Recommendation Report for Planning Permission for Works or Extension to a Dwelling

REF NO: P/106/21/HH

LOCATION: 4 West Front Road
Pagham
PO21 4SY

PROPOSAL: Detached outbuilding.

PROPOSED DETACHED ANNEXE AT 4, WEST FRONT ROAD, PAGHAM FOR MRS. M. SCOTT.

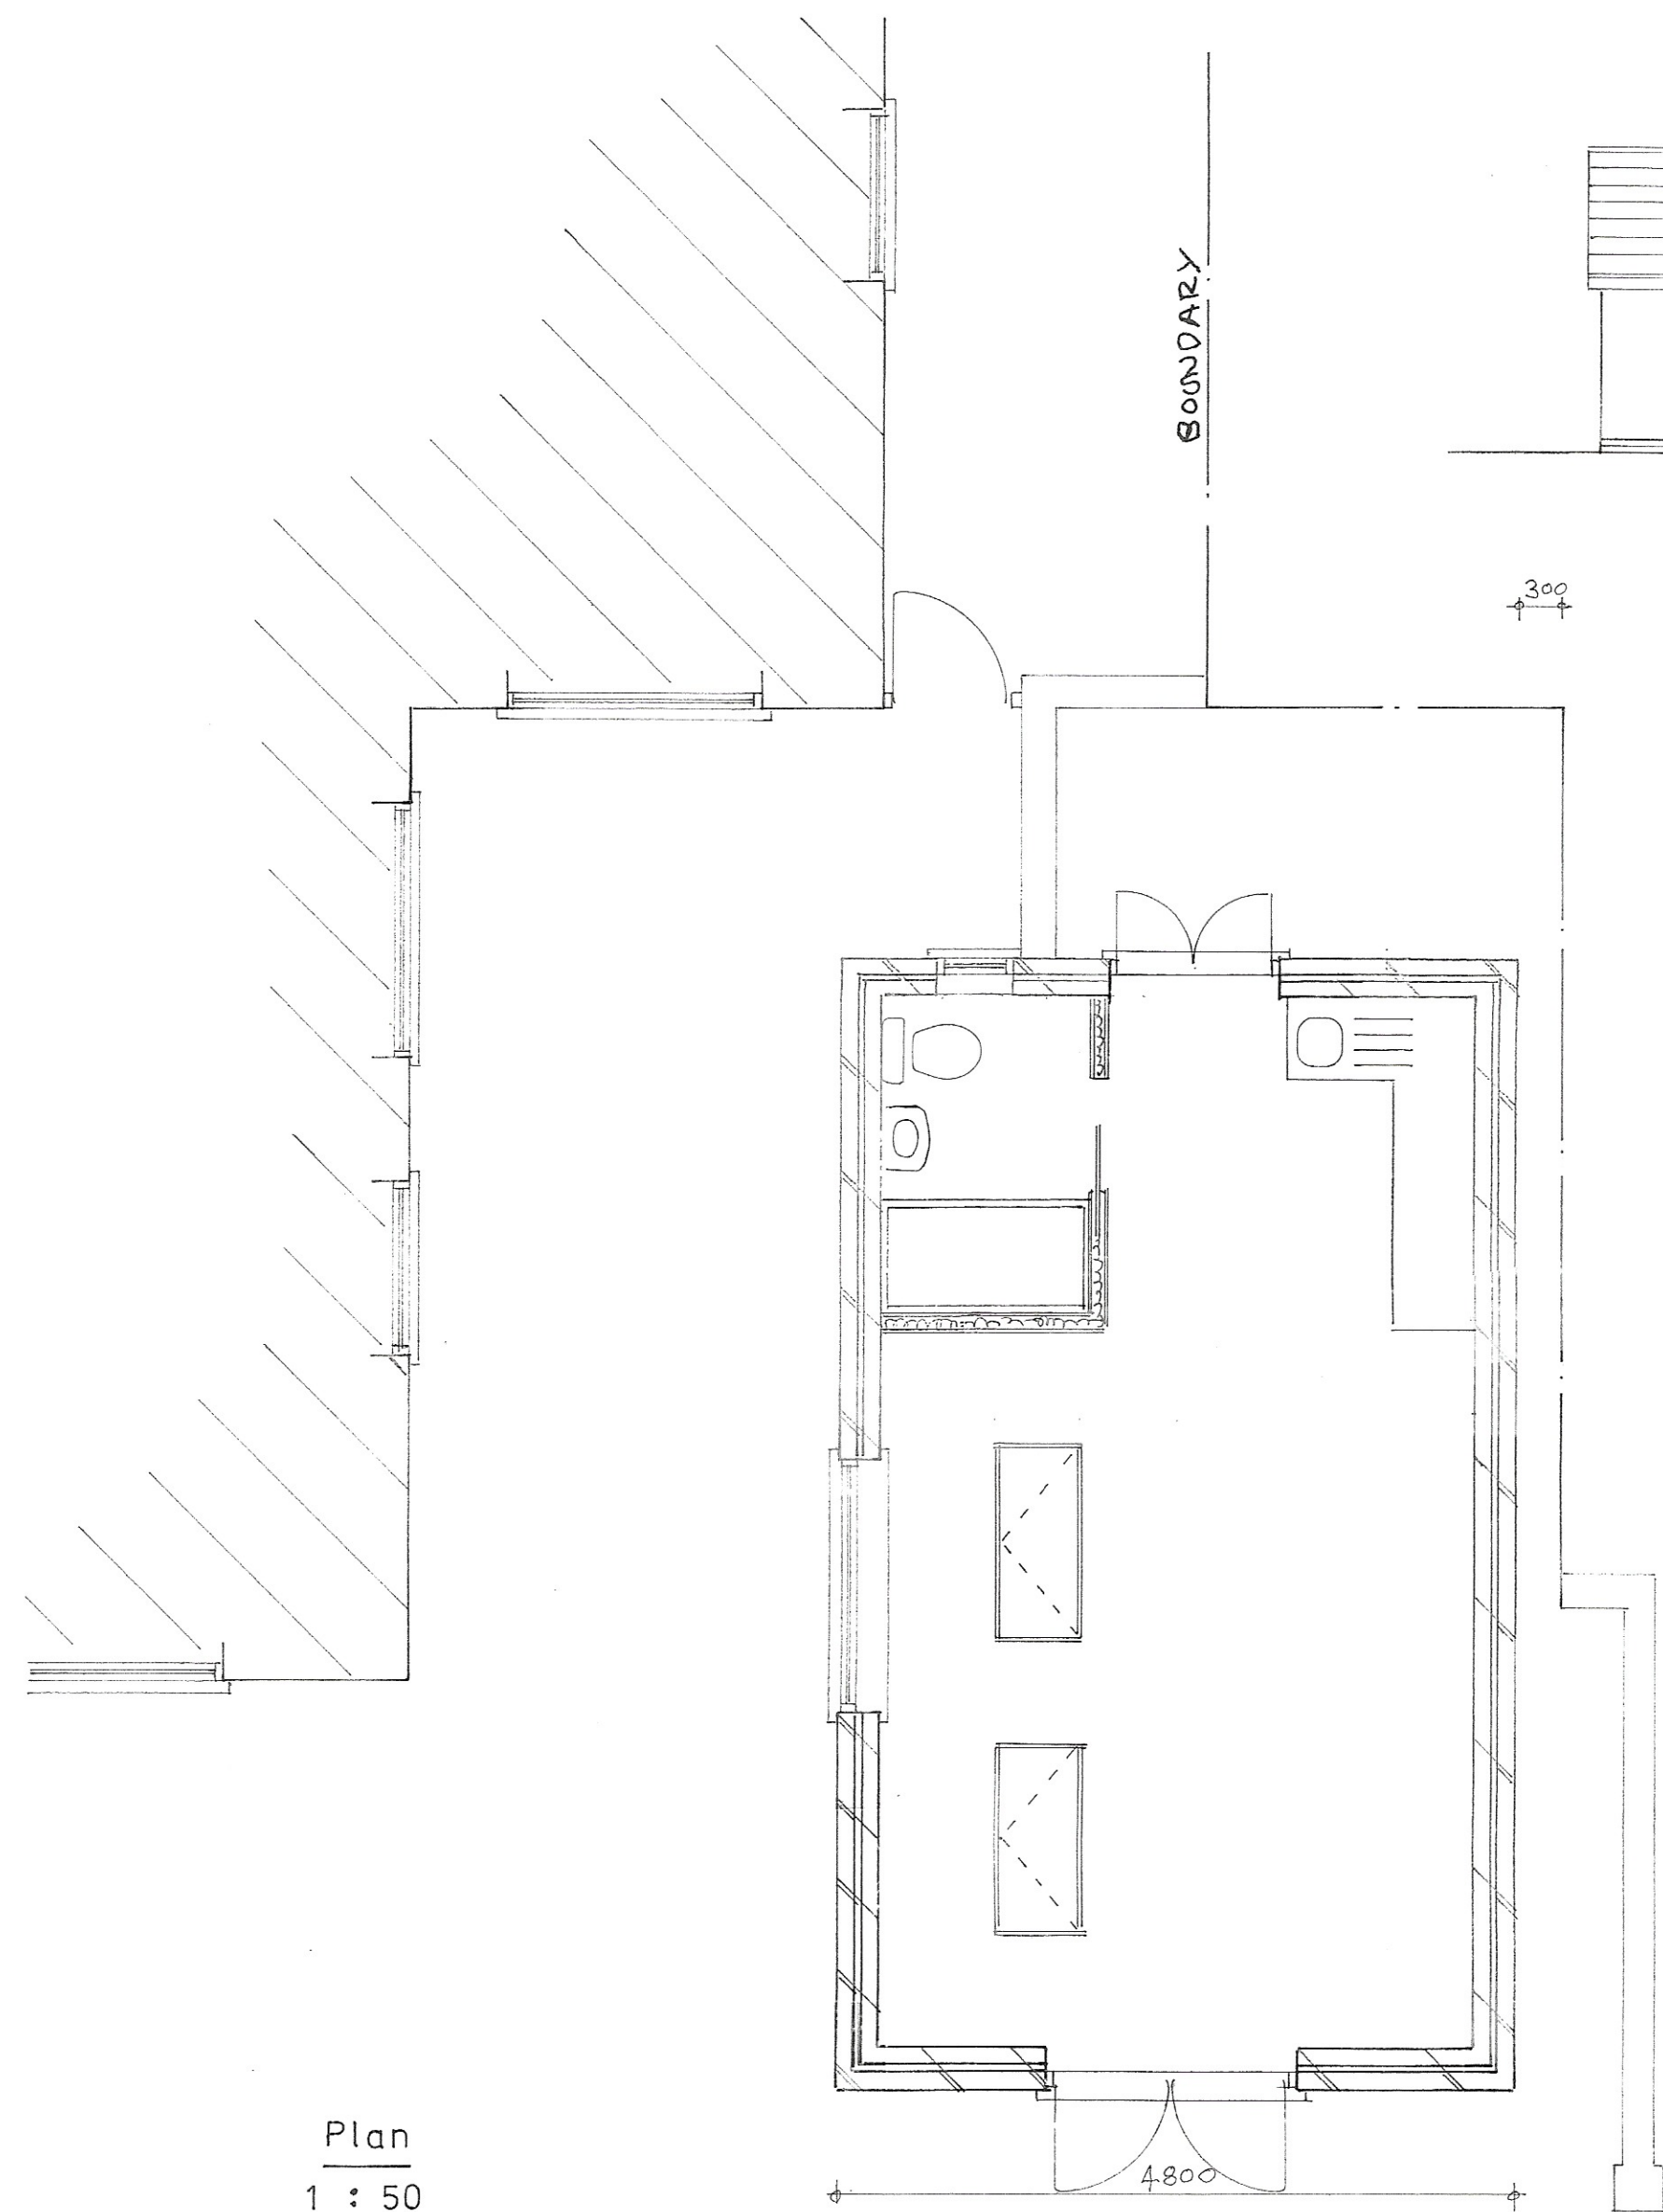
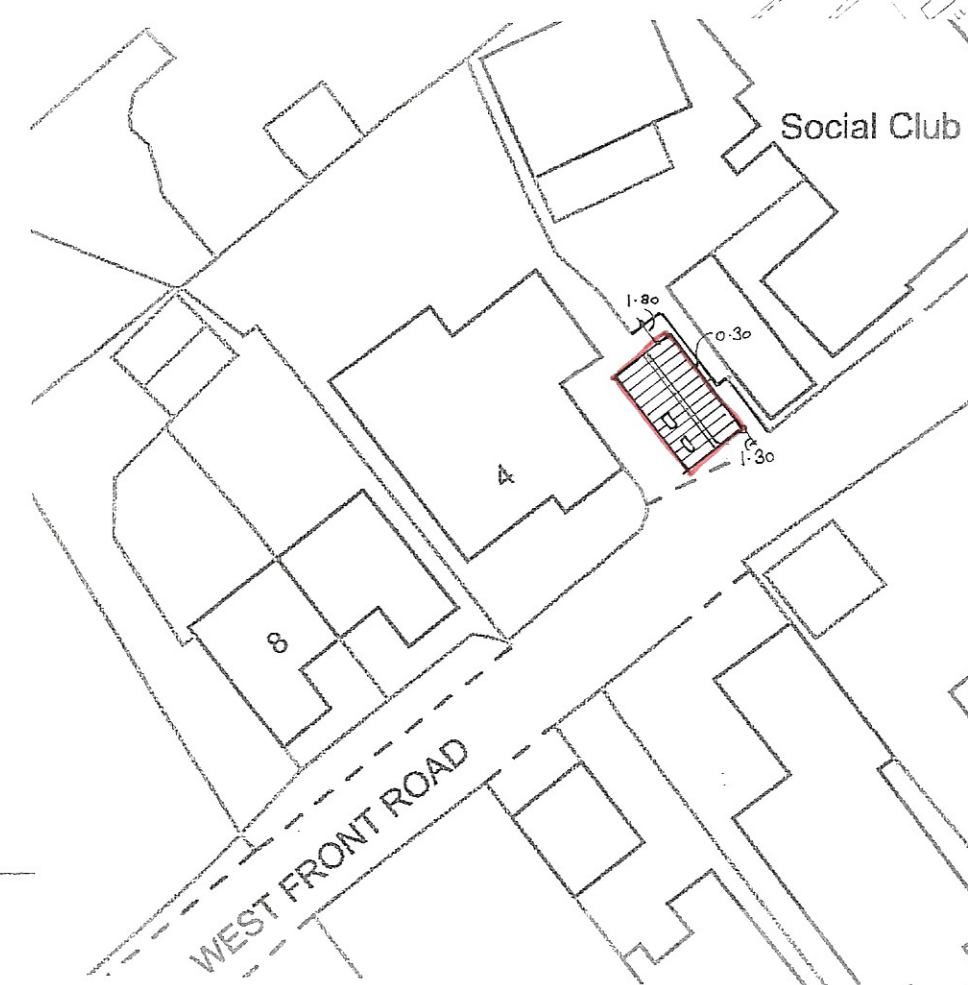
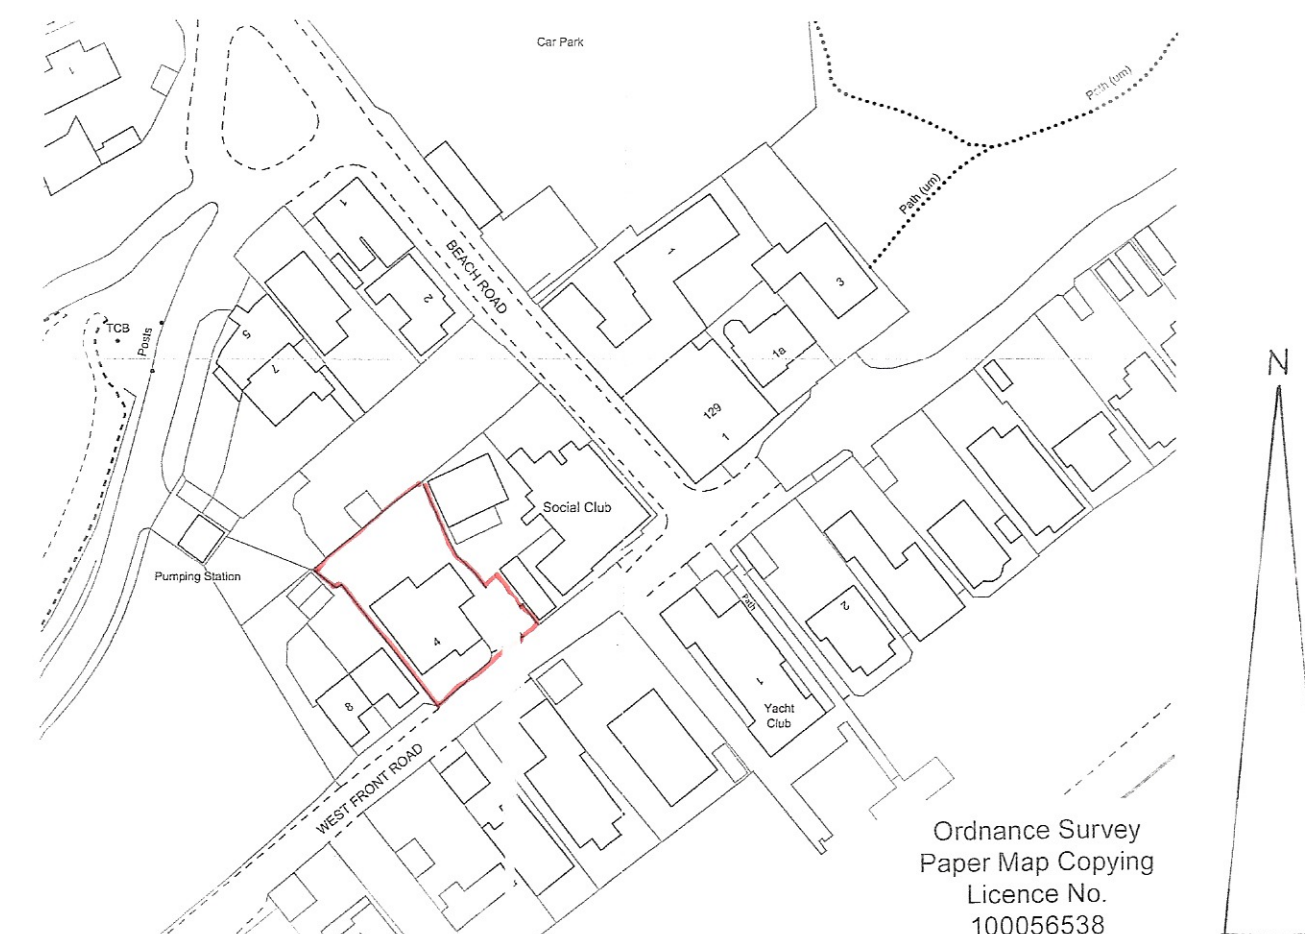
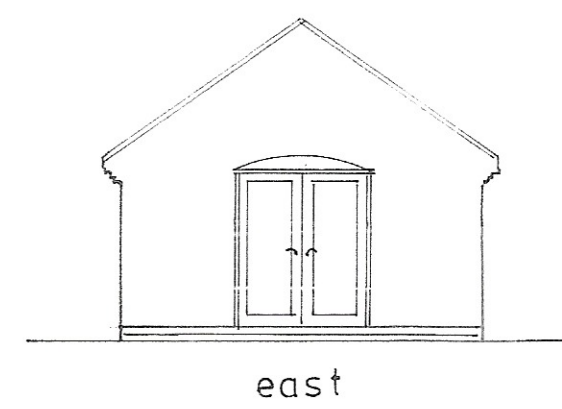
The proposal is for a detached outbuilding to be sited to the front hardstanding area to south east of the property adjacent to side boundary. The proposal will have a length of approximately 8.0m and a depth of approximately 4.8m. The height to top of pitched roof will be approximately 4.41m. There is a gap of around 0.30m remaining to north east side boundary and 1.30m remaining to the front (south east) boundary. It appears from the site and history that there was a previously a garage on the site.

The proposal will have one set of double doors to front, one window to side (southwest) and one set of double doors and one small window to rear. There will also be two new roof lights to southwest roof plane.

Due to siting at front (south east) it will be highly visible from street scene however due to being at single storey it is visually subservient to main dwelling and the roof design integrates with main dwelling roof so complies with policy D DM1 of the Arun Local Plan. There are also many other forward projecting garages/outbuildings in the streetscene.

The proposed outbuilding will be sited to the side (south east) boundary of property. Due to a small gap of 0.30m remaining to north east boundary there is increased risk to overshadowing or overbearing effects to neighbouring property The Pagham Club to north east however due to being at single storey and existing boundary fence there is no adverse harm caused.

Due to new double doors to front (east) elevation there is increased risk to overlooking to neighbouring properties to front (east) however due to location of road and properties to front (east) set back by gardens/fencing there is no adverse harm caused.

Due to new double doors and one new small window to rear (west) elevation there is slight increase risk to overlooking to Pagham Club to north east however due to being at single storey, a gap of around 1.80m remaining to north east boundary and large gap to neighbouring building and boundary fence there is no adverse harm to overlooking effects to neighbouring property to north east.

Due to one new window to south side elevation and two new Velux style roof lights there will be increased risk to overlooking effects to neighbouring properties to south however due to gap of around 5.0m remaining to road and no direct neighbours to south due to road there is no adverse harm to overlooking to neighbouring properties to south so is acceptable.
